From: Ian Brewster
Sent: 31 May 2011 11:14
To: Susan Leeson
Subject: FW: WA/37/11/ Land Adjacent to Walberton Village Hall The Street Walberton BN18 0PQ

Tree Constraints Plan

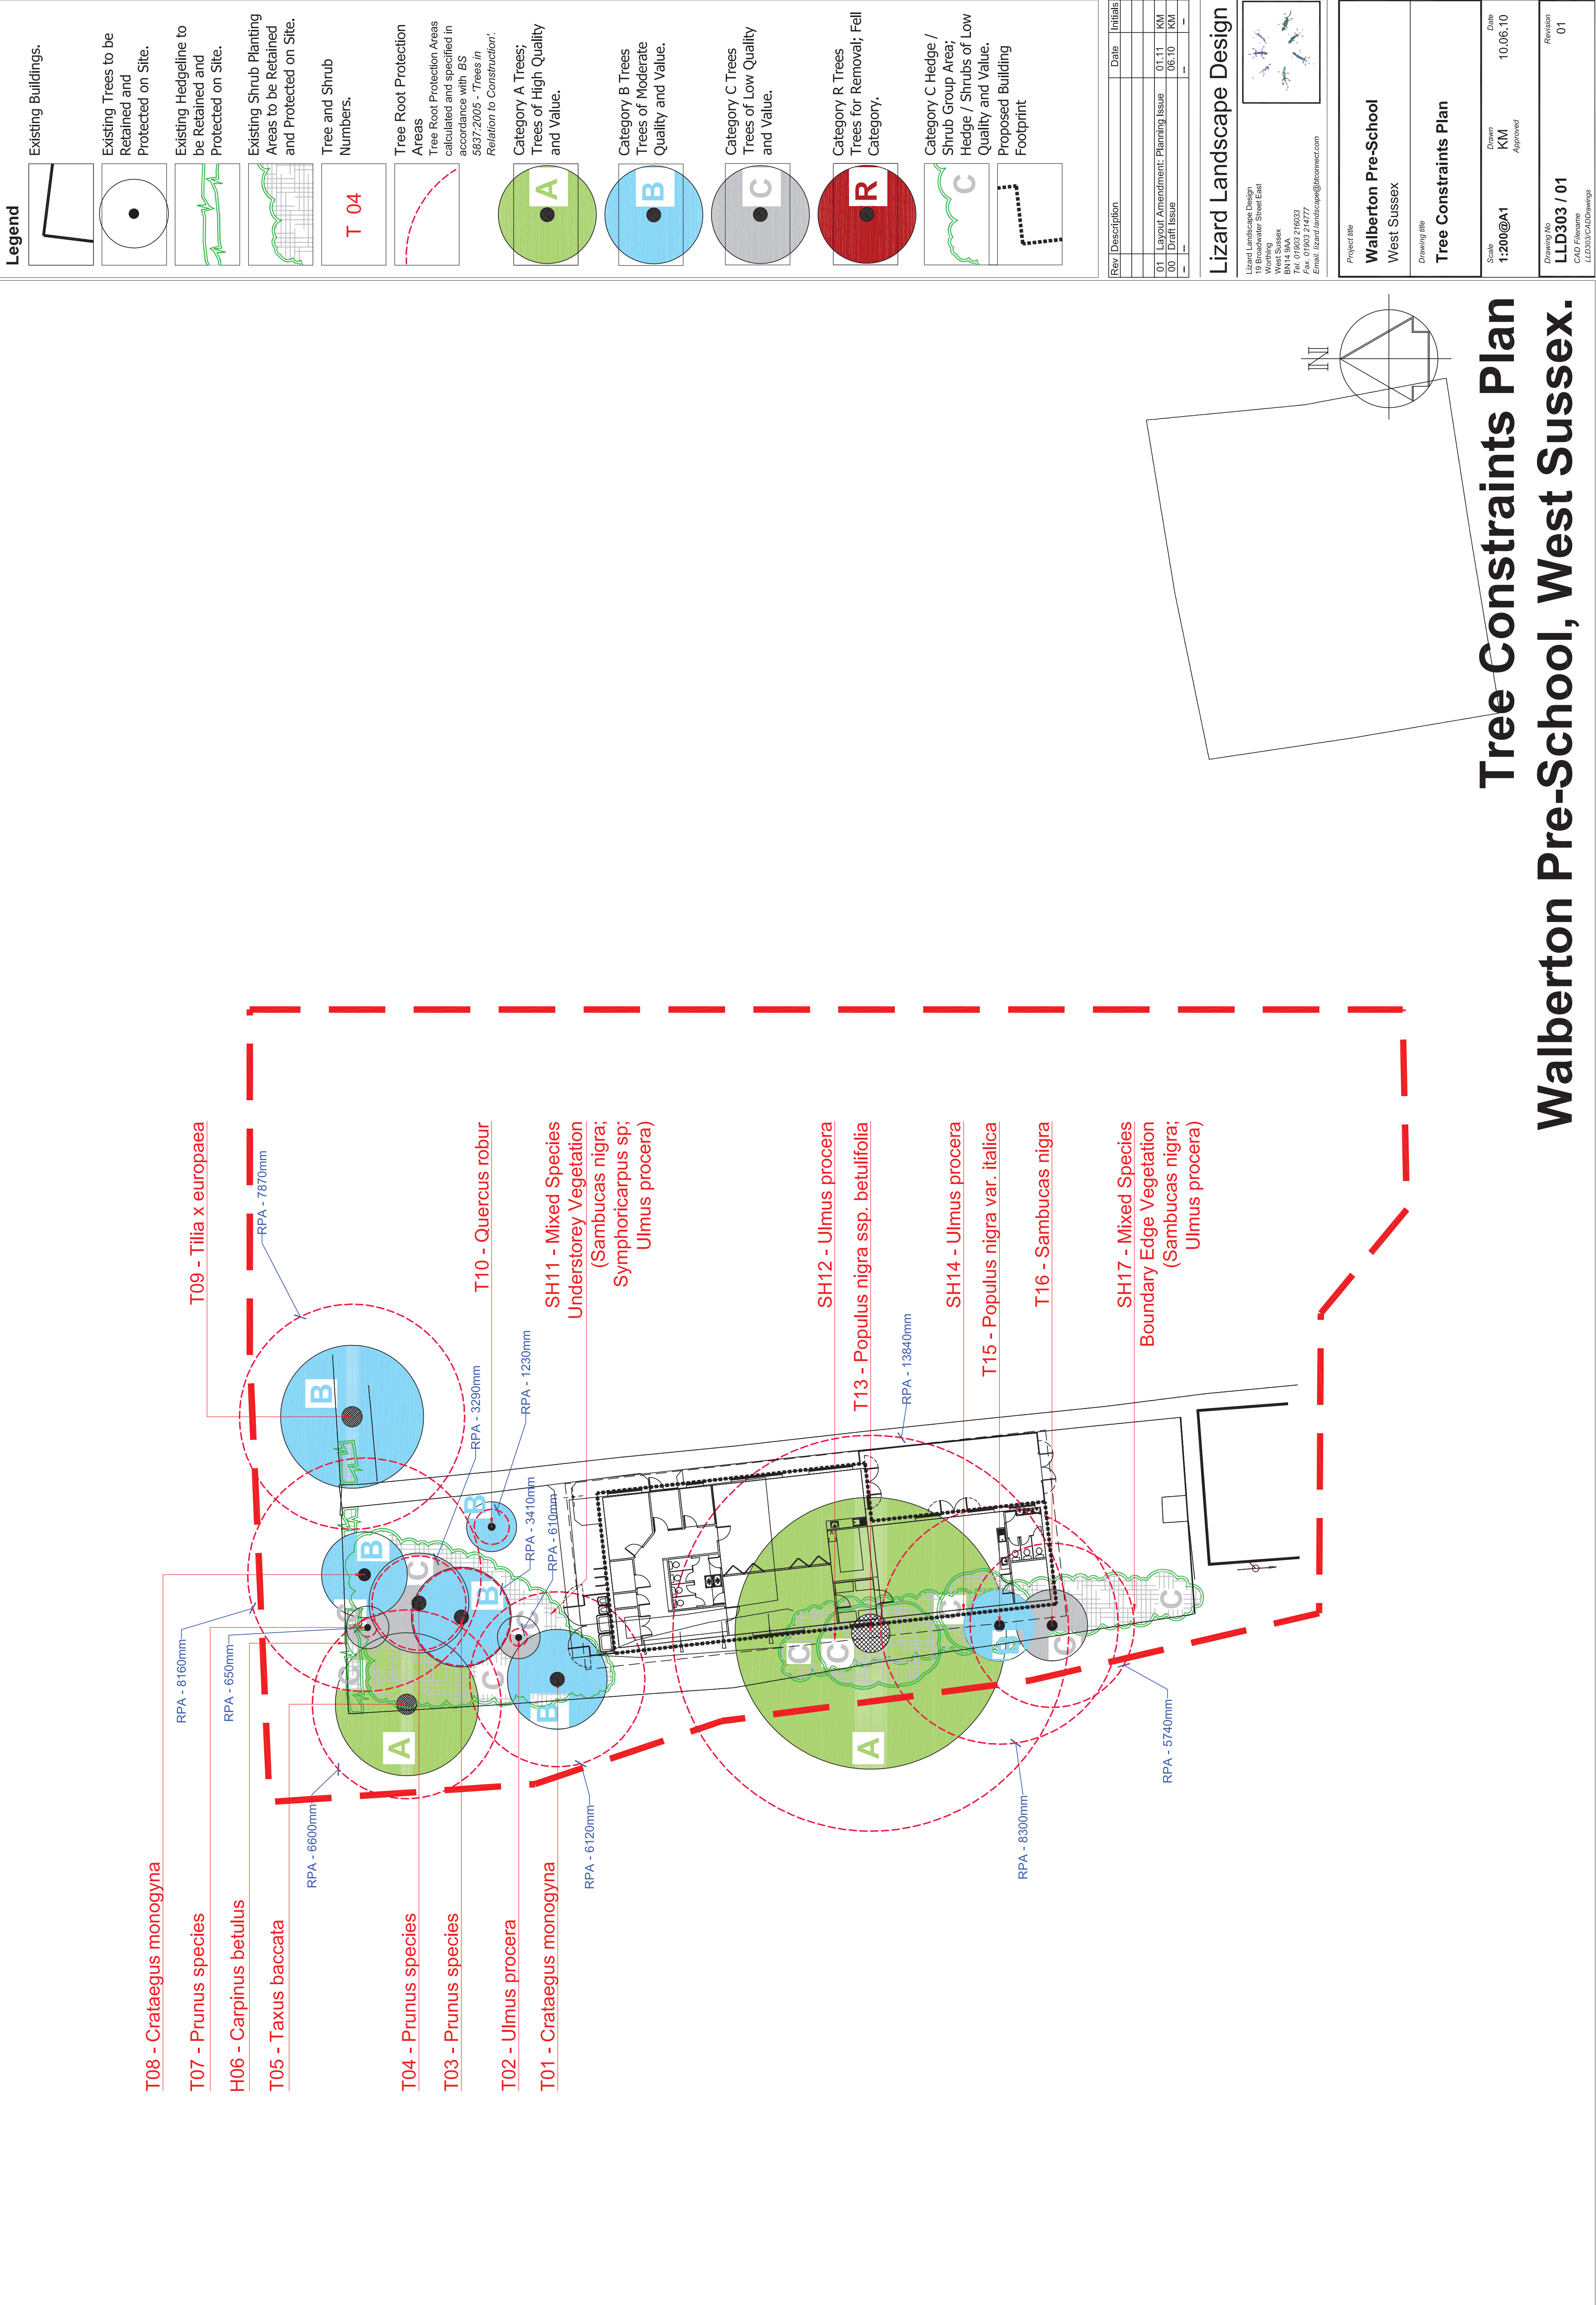
the development proposes the loss of the large Poplar tree identified by the tree consultant as a Downy Black Poplar.

In accordance with BS5837 the tree has been identified by the tree consultant as a category A, which describes the following:

The tree is a Poplar growing from a clay soil. In accordance with National House Building Council's Recommendations this is a high water demanding species and has the potential to exacerbate shrinkage/expansion of clay soils. The NHBC recommend deep and special foundations for built structures within the tree's zone of influence to counteract heave once the tree has been felled. This needs to be investigated by the developer and accepted by the Planning Officer/Building Control Officer.

The tree provides good amenity and should be retained. However compensatory planting for its loss should be considered as part of the proposal. It would be appropriate to plant with same species at sufficient distance from the new build. A line of Downy Black Poplar located 3m to the east of the footpath within the recreation ground is suggested.
